From: Claire Booth
Sent: 09 January 2013 11:25
To: Jane Tucker
Subject: FW: Consultation on planning application 3/2012/1048 Sheepfold Farm, Balderstone Hall Lane, Balderstone

From: Hornby, Mark [mailto:Mark.Hornby@lancashire.gov.uk]
Sent: 07 January 2013 15:11
To: Claire Booth
Cc: ENV EPP Customer Service Area East
Subject: FW: Consultation on planning application 3/2012/1048 Sheepfold Farm, Balderstone Hall Lane, Balderstone

Proposed Site Plan 1:500

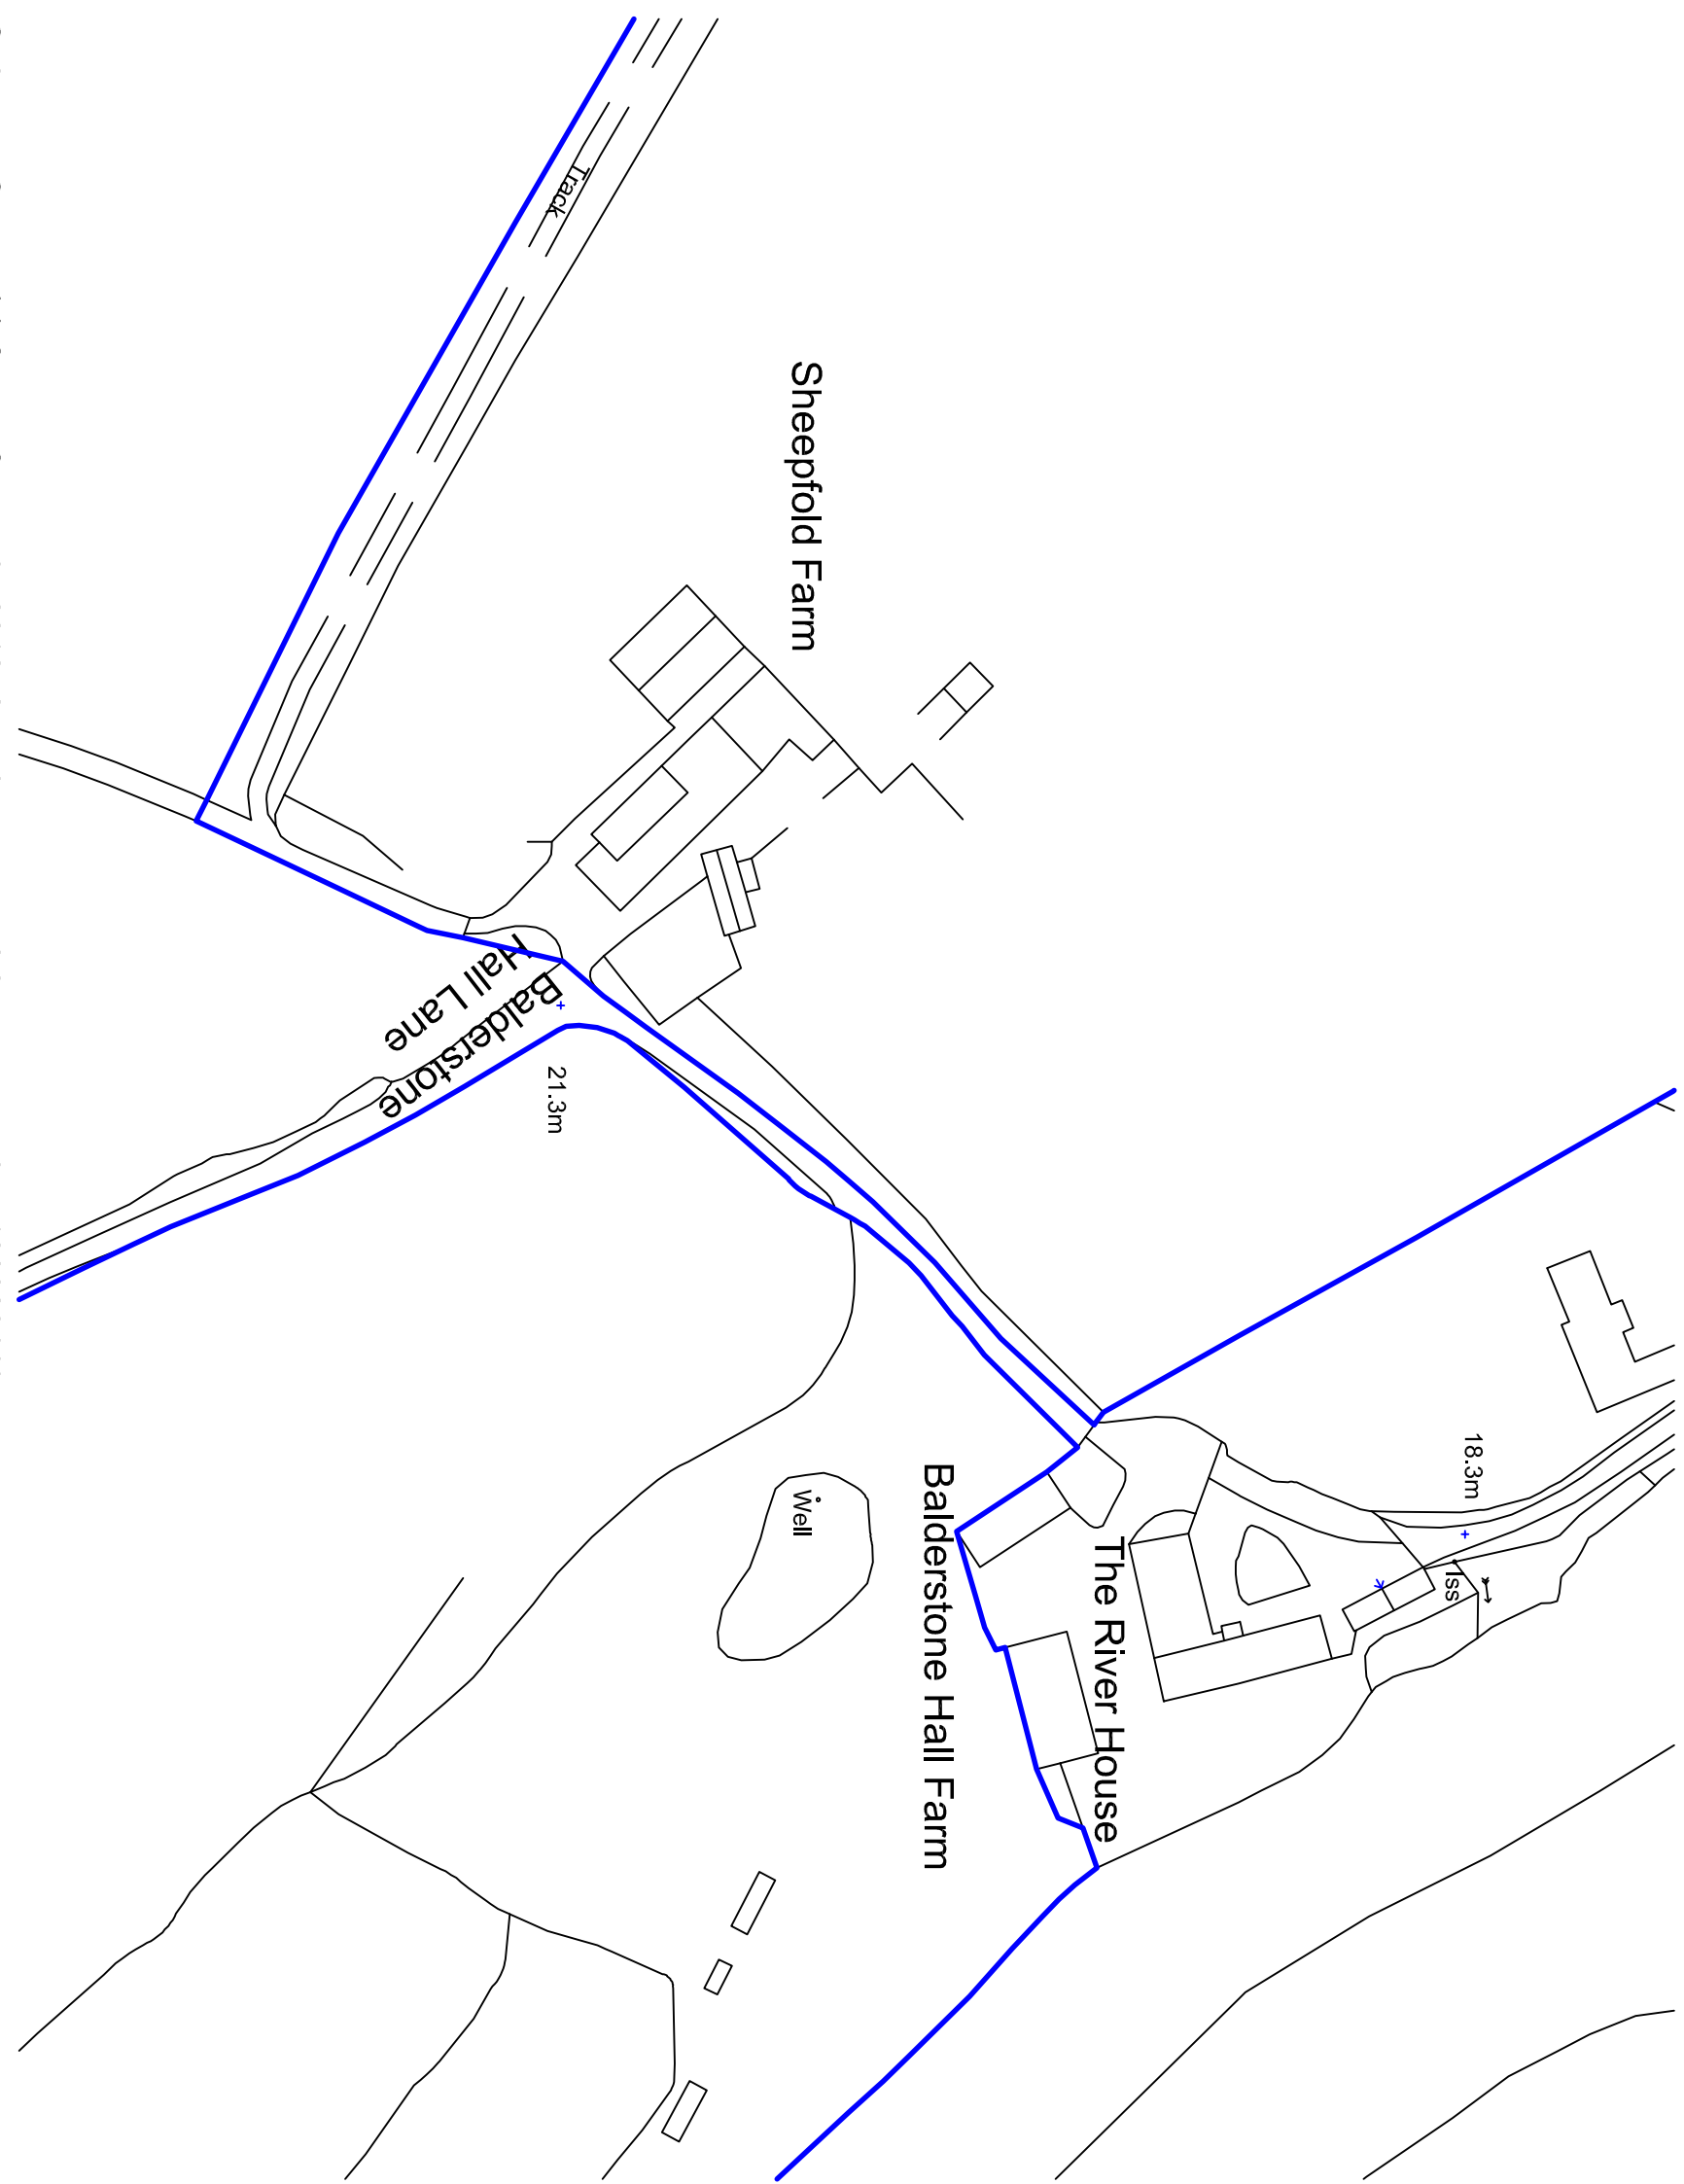
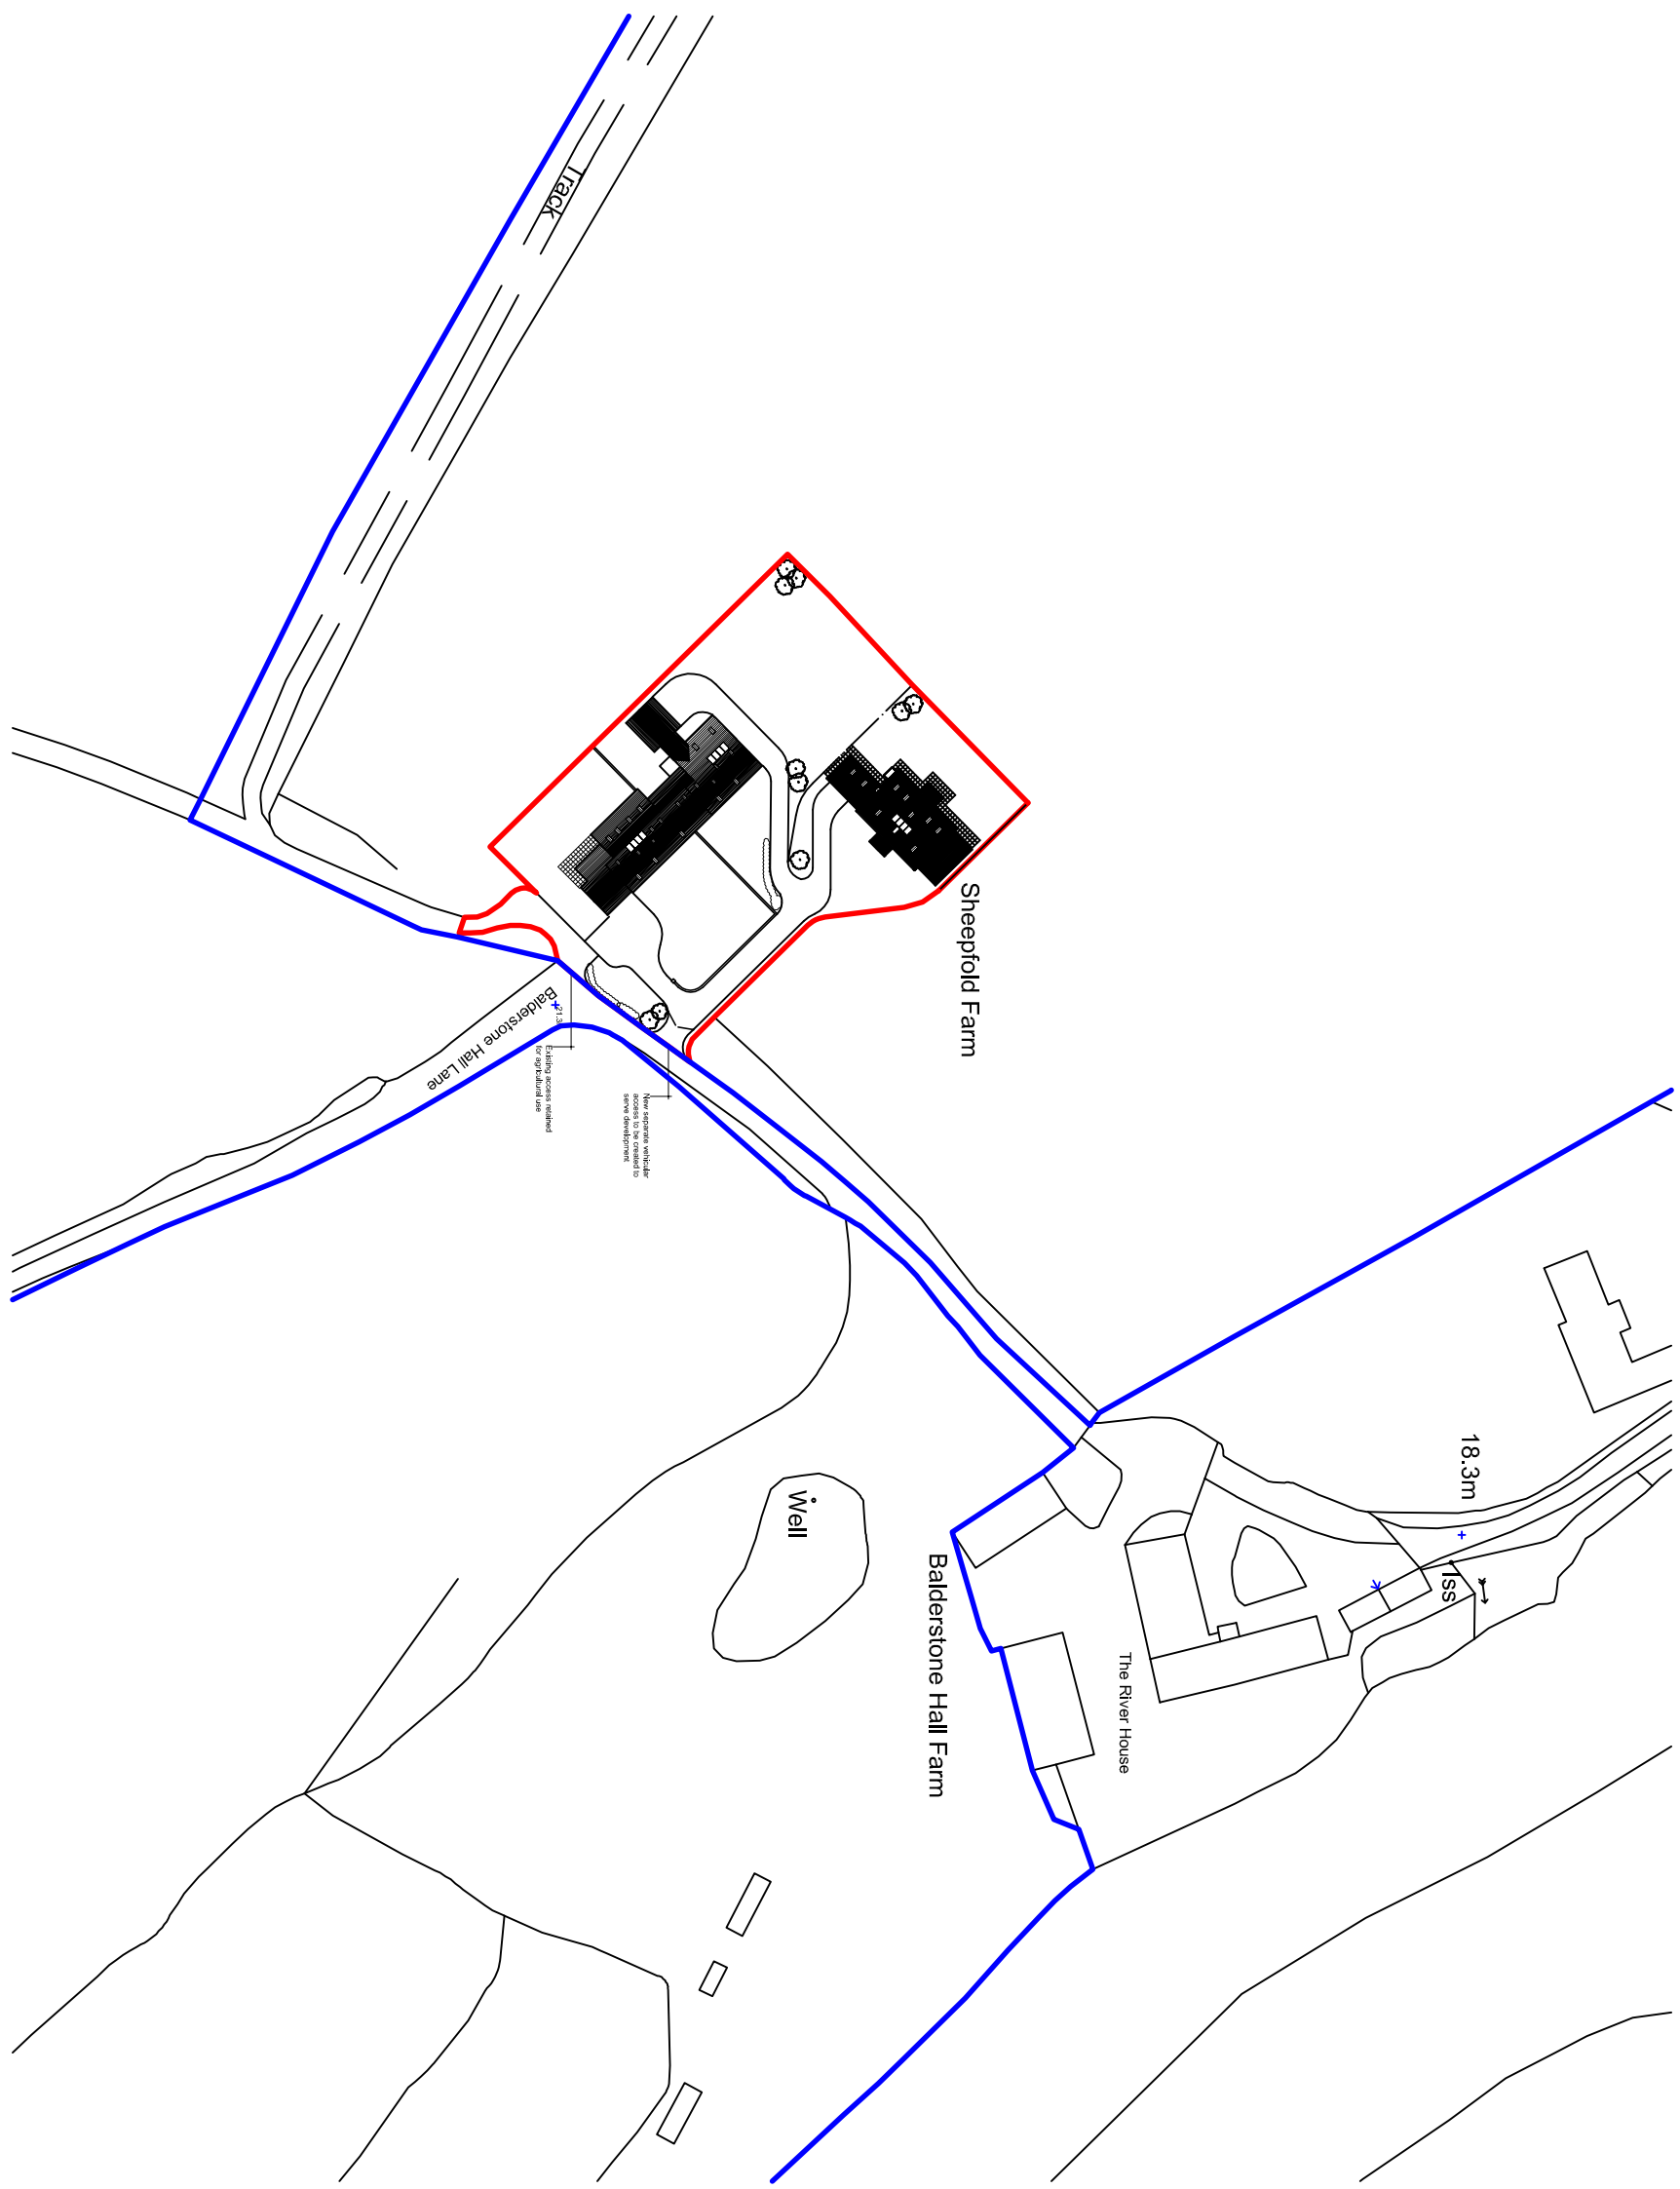
Whilst I have no objection in principle to a development of this scale at the site, the proposed new access driveway would appear to have poorer sight lines along Balderstone Hall Lane than the existing access which benefits from clear views in both directions. No measured visibility splay is detailed on the submitted plans however I would estimate from my site visit that a maximum of 2m x 30m would be the best that could be achieved at the new access location, which is considerably less than the minimum of 2m x 50m I would consider necessary.

I must therefore recommend a refusal of this application as it stands on highway safety grounds due to insufficient visibility at the proposed new vehicle access.
